Application for Planning Permission

Development: Replacement of existing Portacabin with new single storey modular cabin for use as an ancillary building to the existing site. Excavate grounds of mixed material to create trench for new power, water and drainage. Install drainage pipework and associated items, including connection to existing, new or planned network. Install electrical meters, transformers and associated items as required. Excavations to be finished in concrete to match existing hardstand. New planters, wildlife houses and greenspace.

Location: Environment Agency, Ford Depot Station Road Ford BN18 0BH

Drawing Title:
EXISTING LOCATION PLAN

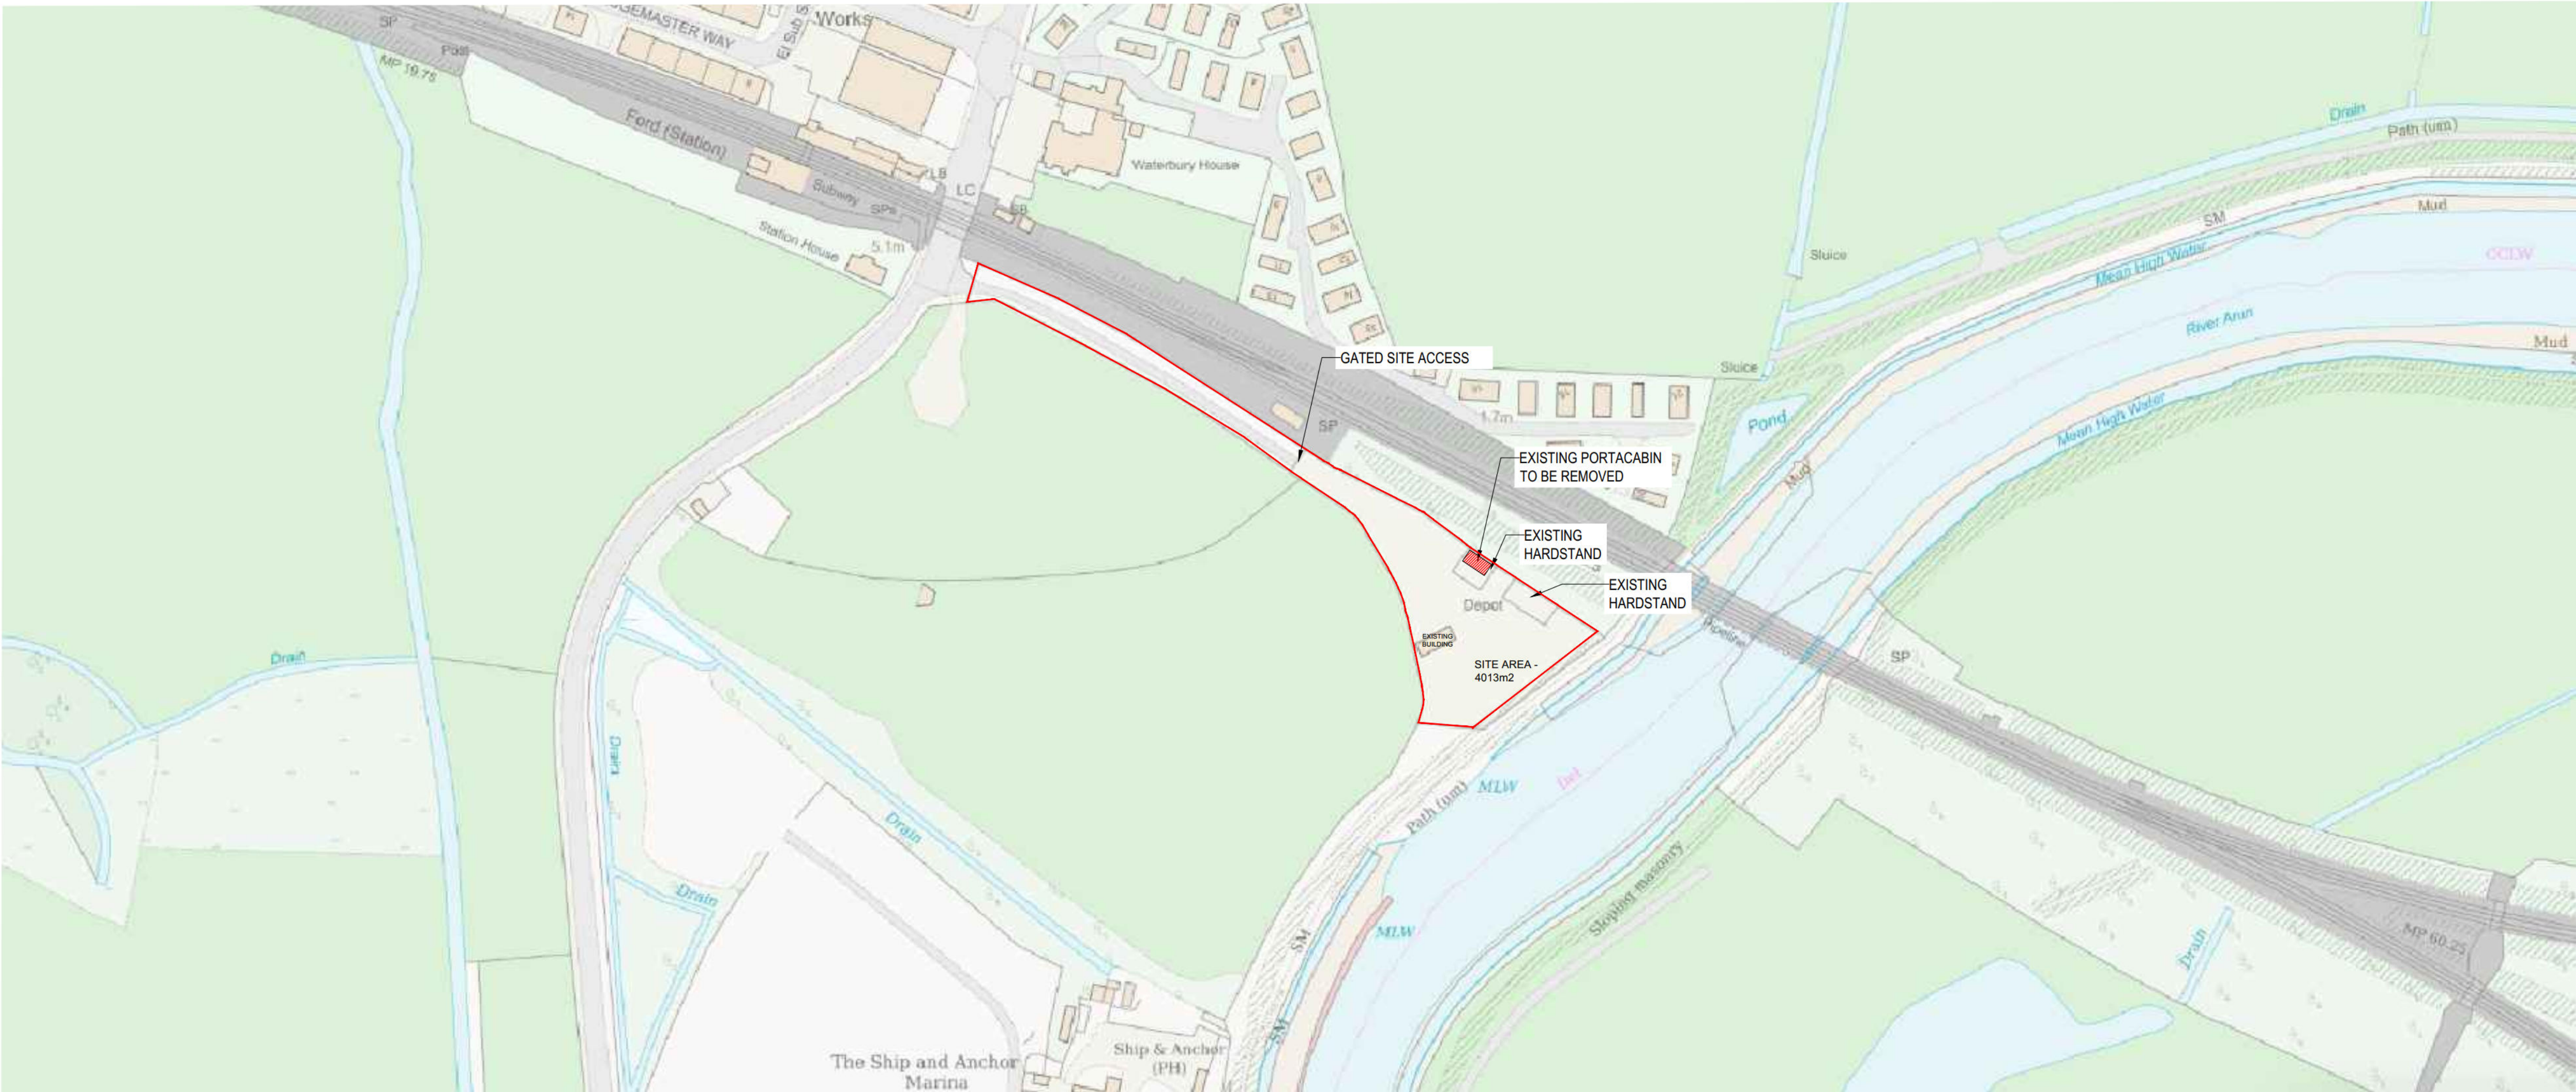
Location Plan

The plan does not indicate the scale, please amend.
